**The Northern Road Upgrade between Mersey Road, Bringelly and Glenmore Parkway,
Glenmore Park - Critical State Infrastructure Development (SSD 7127)**

OEH has reviewed the Environmental Impact Statement supporting the proposal and provides the attached comments in relation to biodiversity and floodplain risk management.

Office of Environment and Heritage comments on The Northern Road Upgrade between Mersey Road, Bringelly and Glenmore Parkway, Glenmore Park - Critical State Infrastructure Development (SSD 7127)

Figure 3-1 | Vegetation survey locations

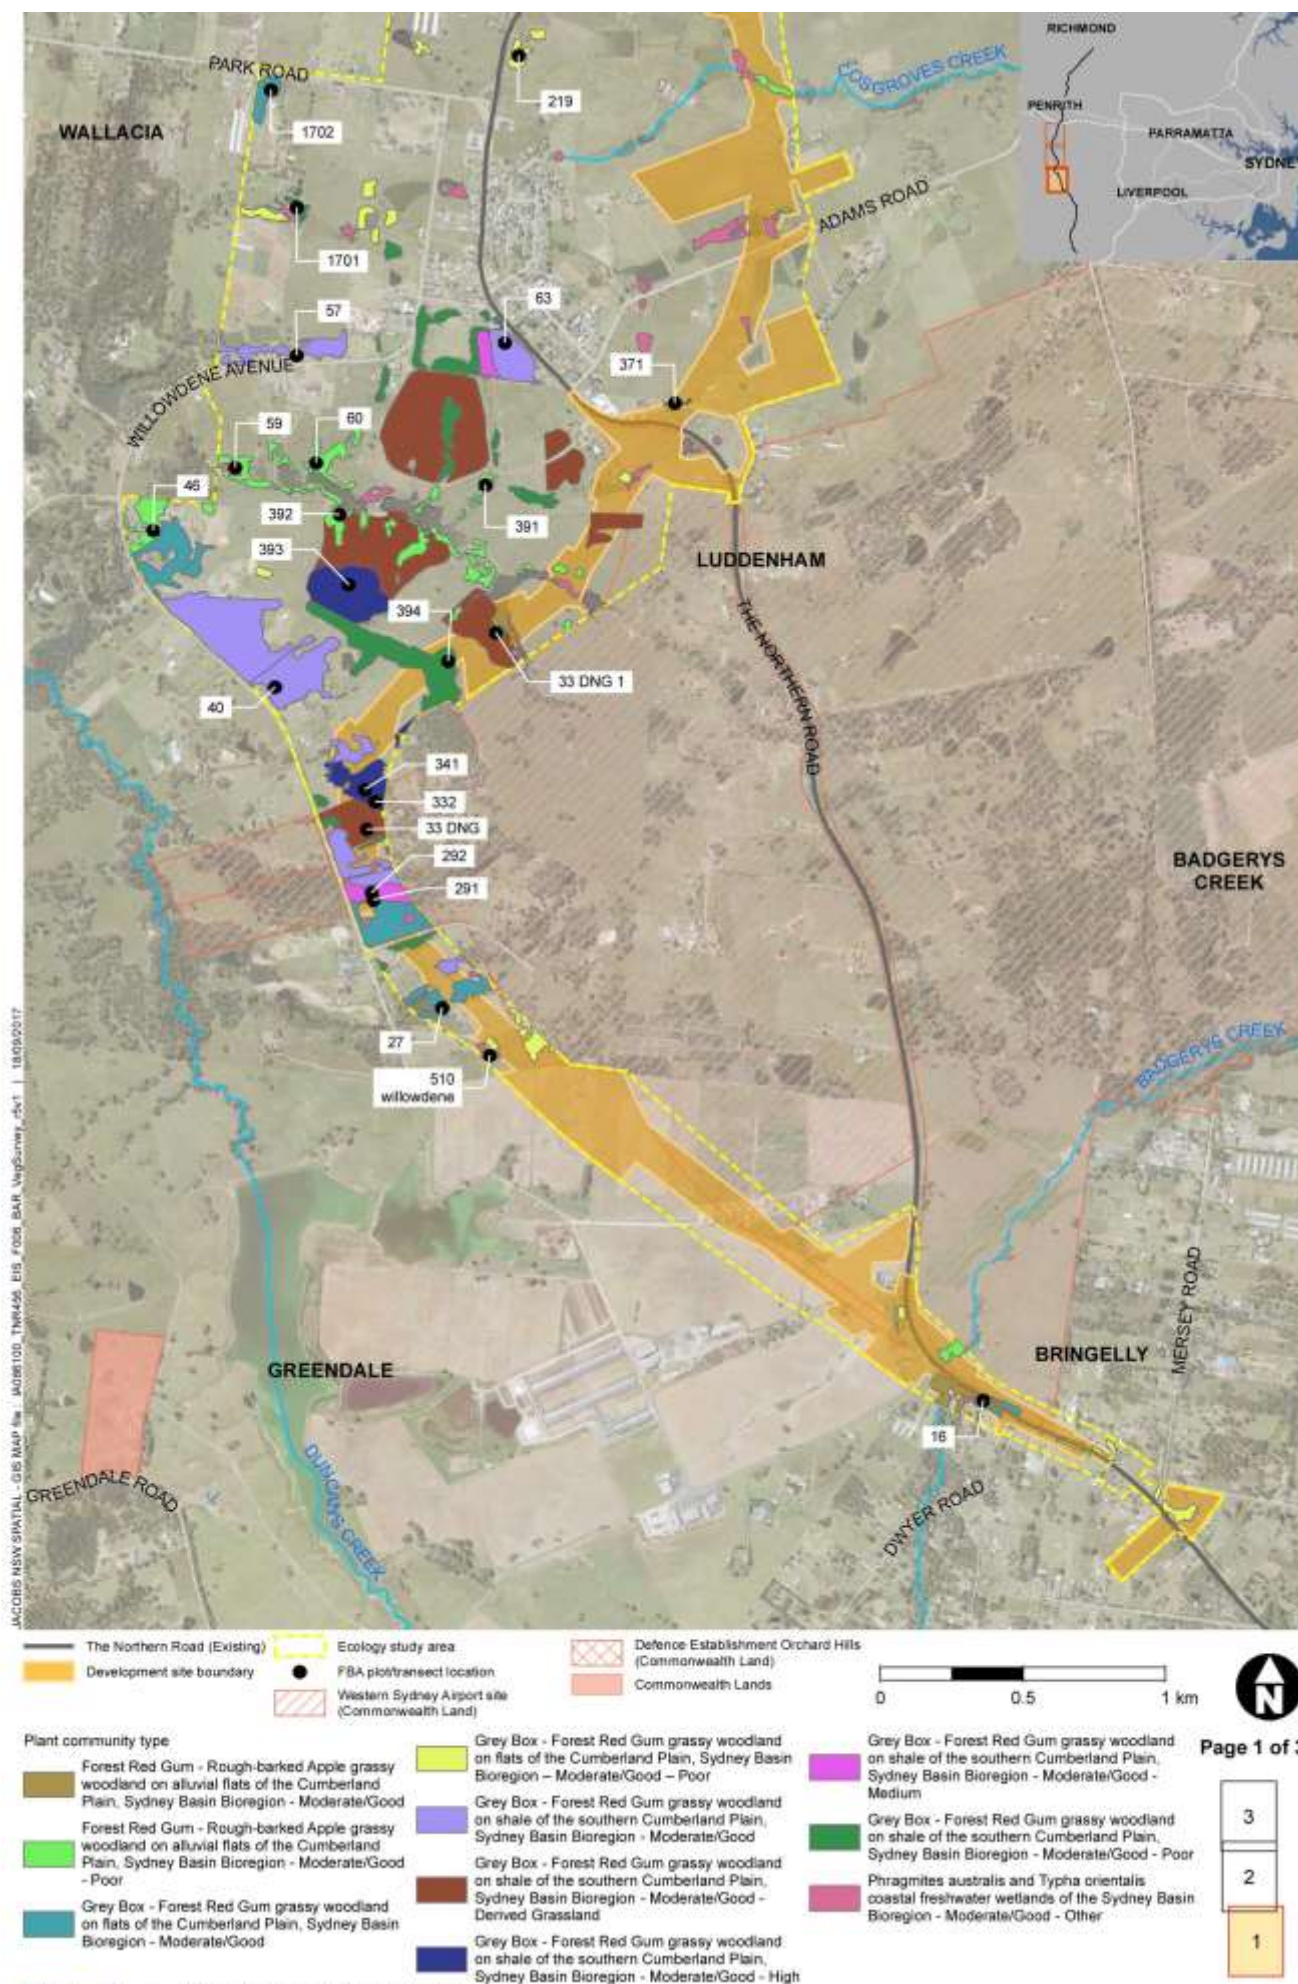
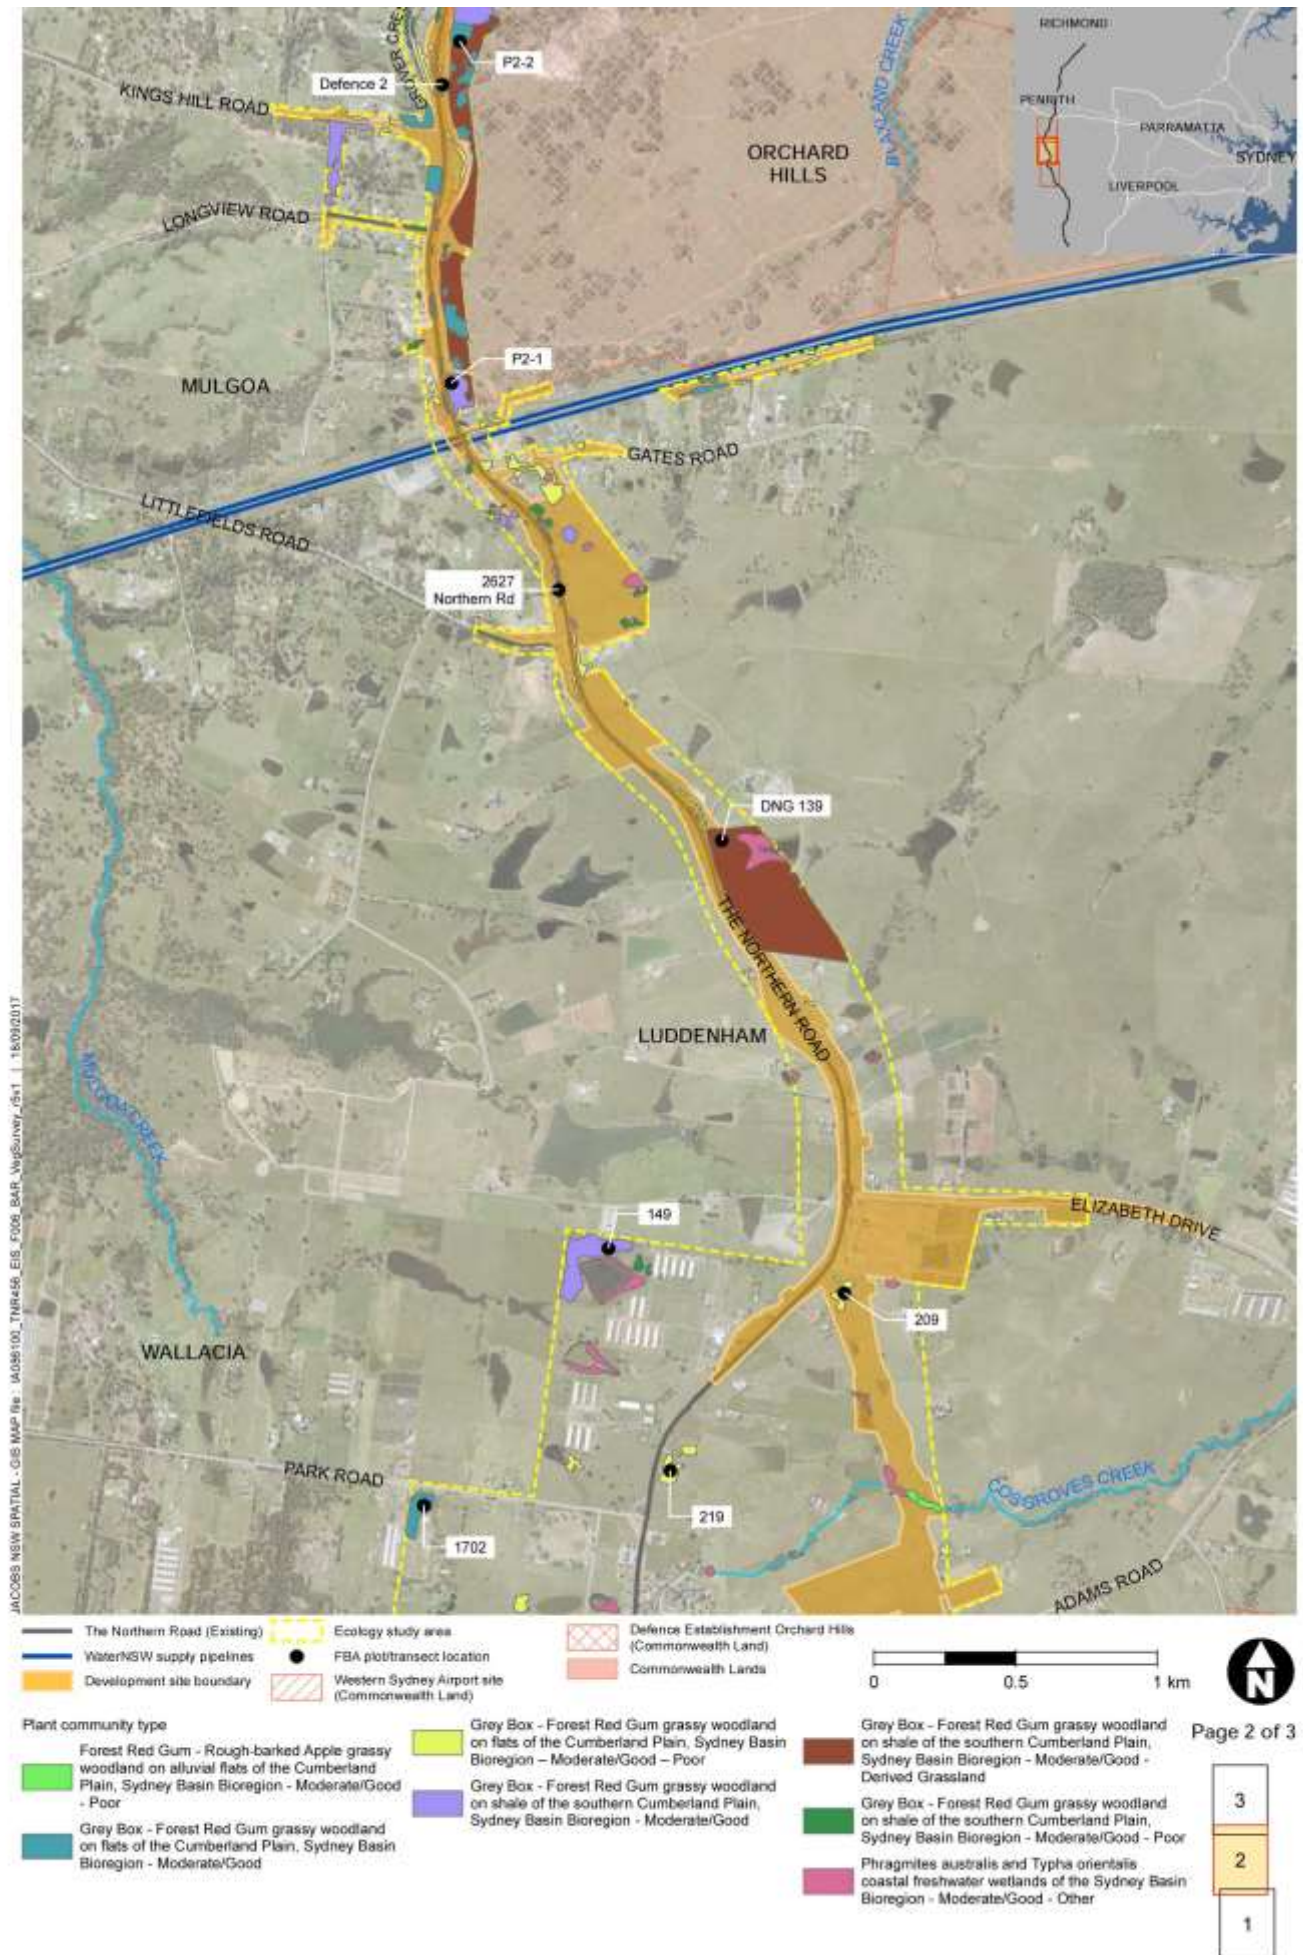
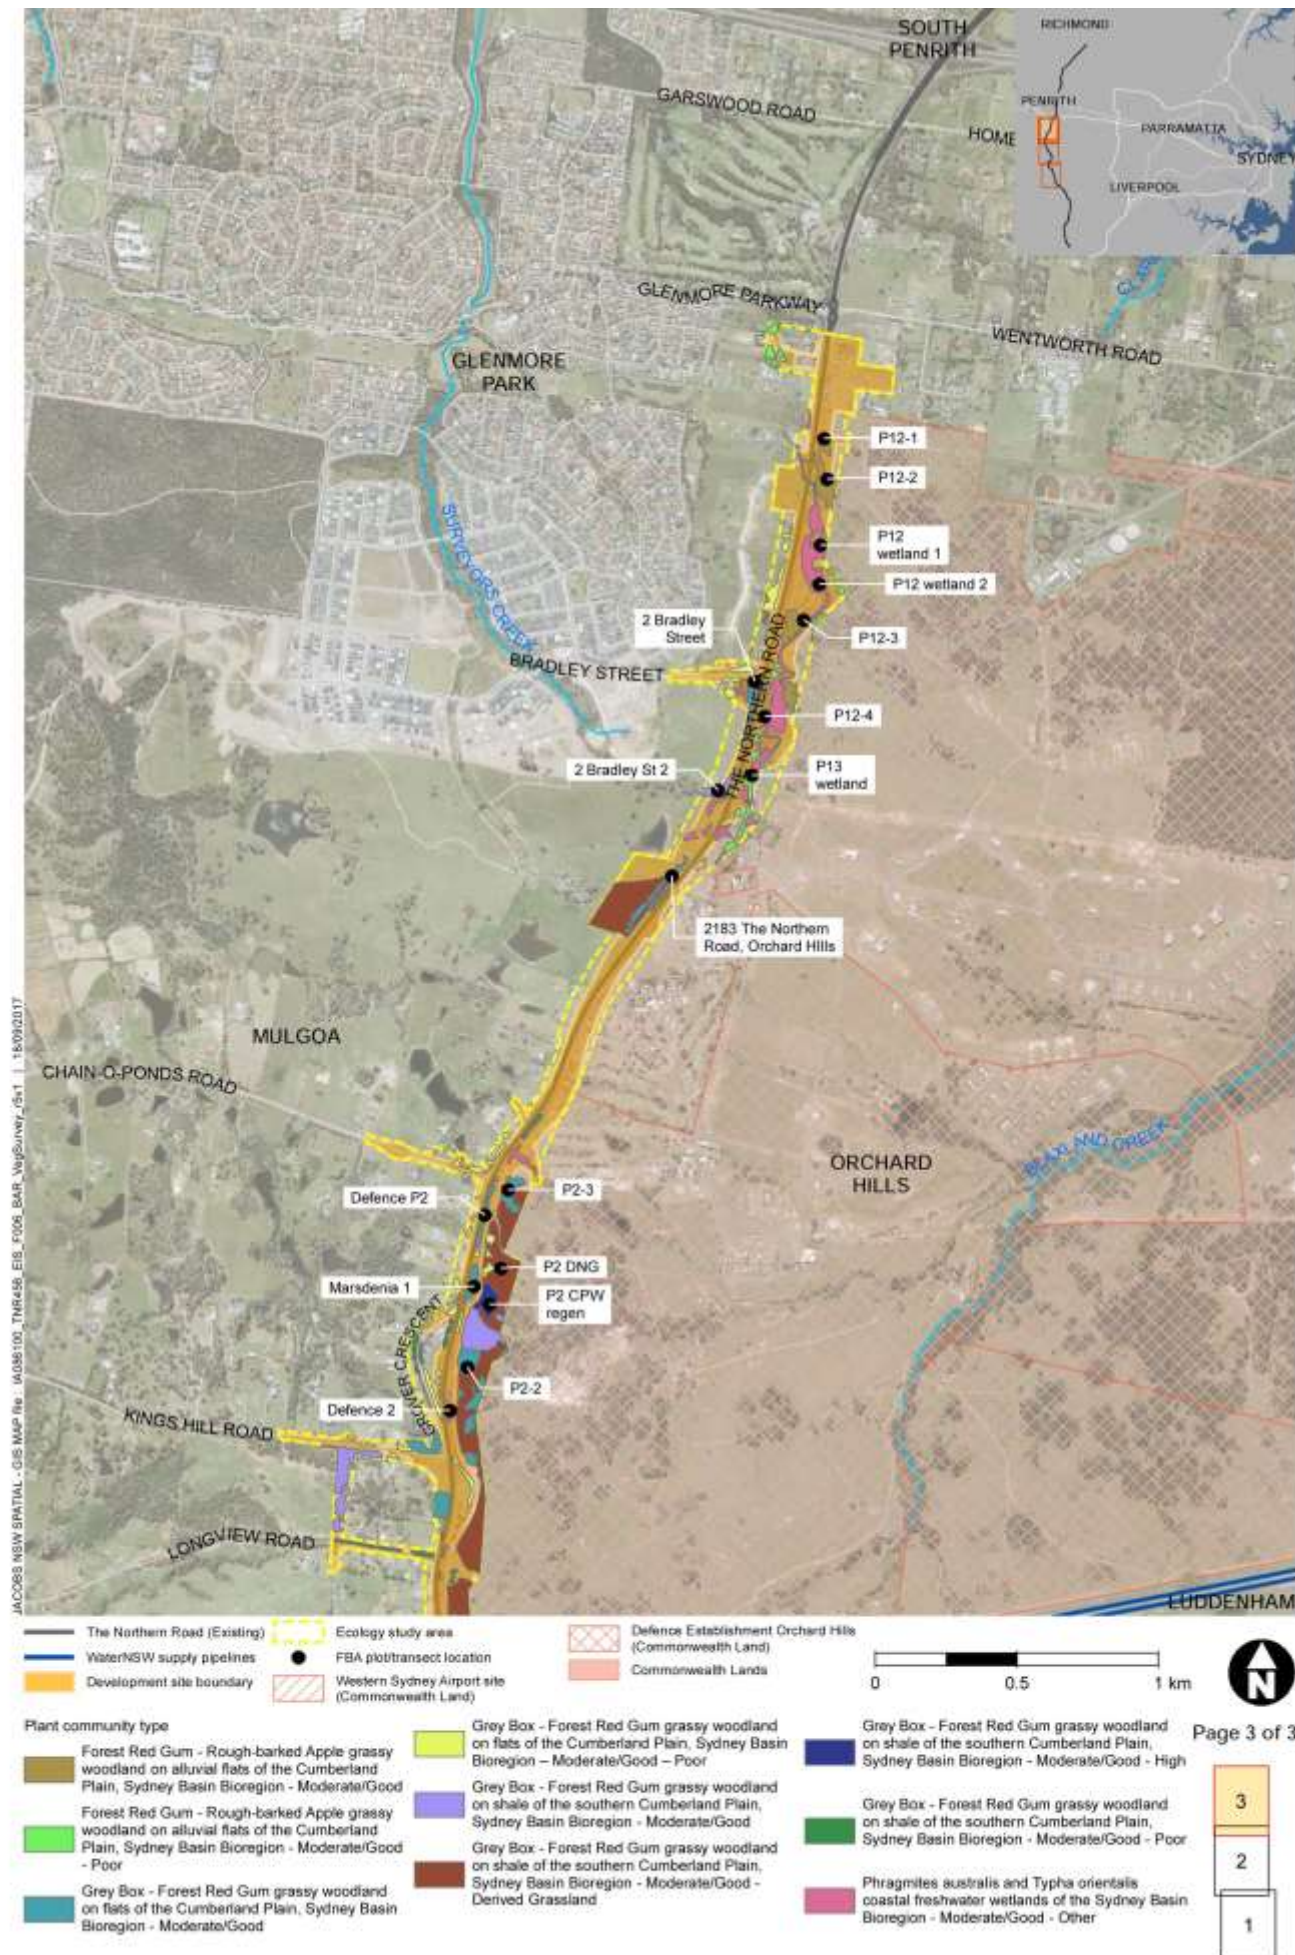
- The legend of Figure 3.1 (Vegetation survey locations) refers to HN528 as being in '*low*' condition, however, Table 3.2 and the credit calculator, HN528 is in '*Moderate/Good*' or '*Moderate/Good_Poor*' condition. There also seems to be some duplication of PCT names in the legend of Figure 3.1. It is recommended these errors be addressed in the revised BAR.
- Table 6.1 (Summary of biodiversity values assessed under the FBA) is missing the area of impact (4.68 ha) for vegetation zone 4 (PCT 849), meaning the total of 6.67 ha shown for '*Grey Box - Forest Red Gum grassy woodland on flats of the Cumberland Plain, Sydney Basin Bioregion*' should be 11.35 ha. It is recommended this error be addressed in the revised BAR (it is understood vegetation zone 4 is later excluded (Section 8 of the BAR) from further assessment due to having a site value score of <17).
